Re: Izabel Subdivision – Drainage Certification
COA Project 765981 (DRB 1003856)

RE: Izabel Subdivision (Q-10/D003)
Engineers Certification for Release of Financial Guaranty
Engineers Stamp dated 05/12/2005
Engineers Certification dated 02/10/2005

Based upon the information provided in your Engineer's Certification Submittal dated 10/22/2007, Hydrology is not able to approve the above referenced plan for the Grading and Drainage Certification for Release of Financial Guaranty.

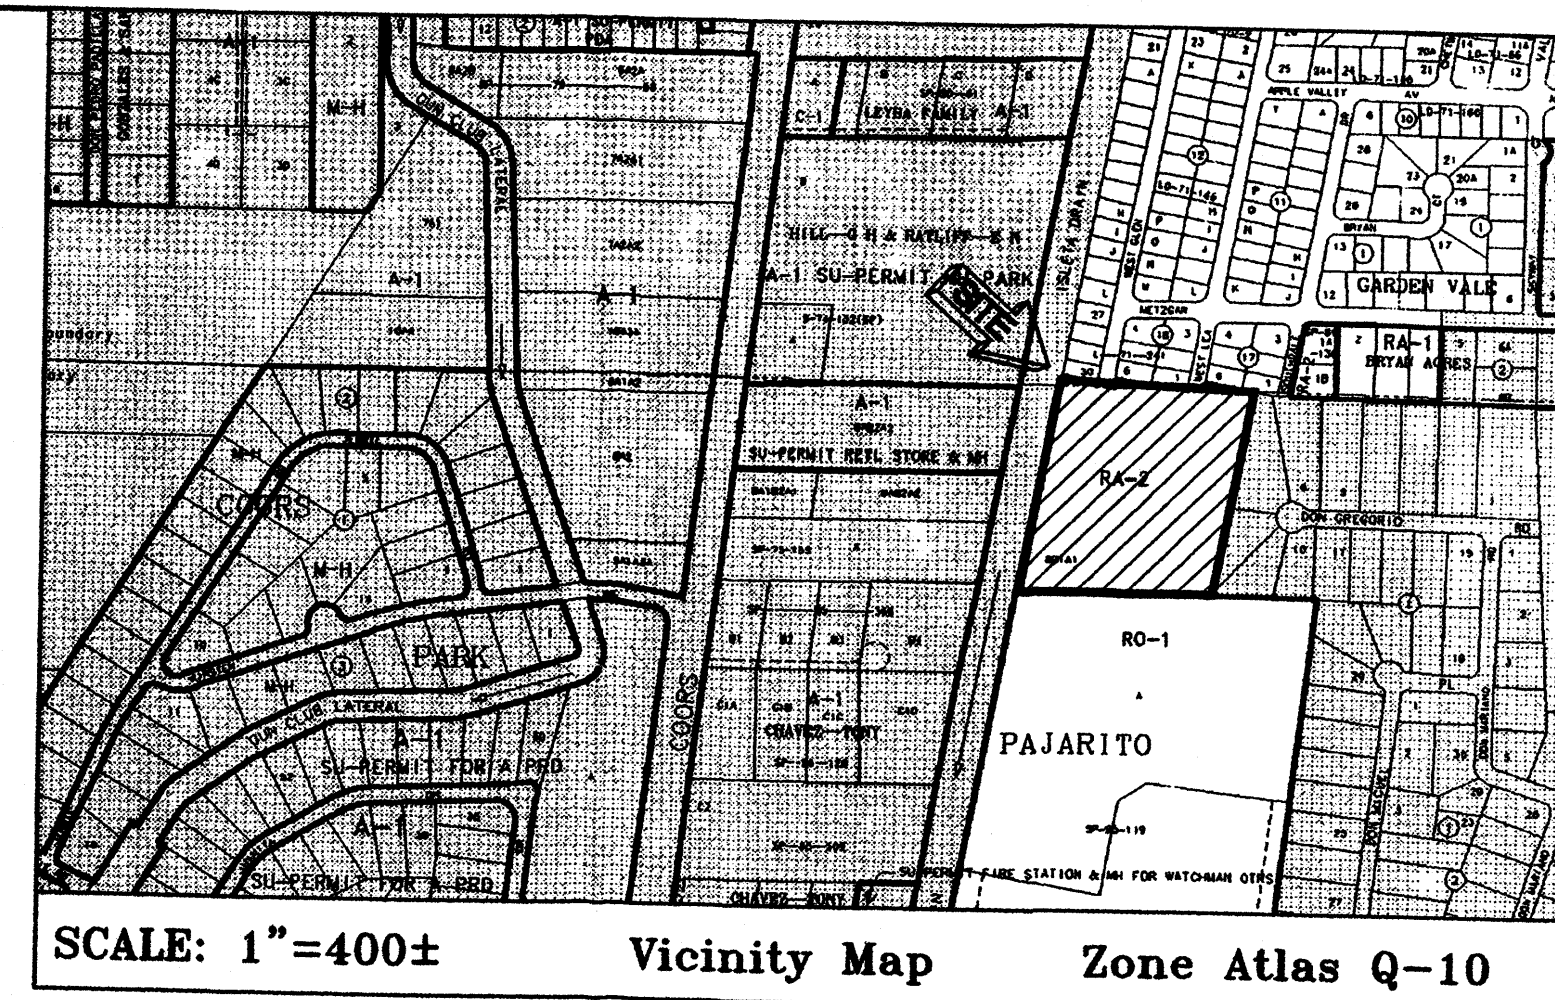
1. Provide as-built elevations for the entire site. The certifying language denotes some minor ponding within the gutter; this will need to be reflected on the plan.

With respect to the submitted Drainage Certification document for the referenced project, I further certify that the house pads are graded such that they drain to the street section.
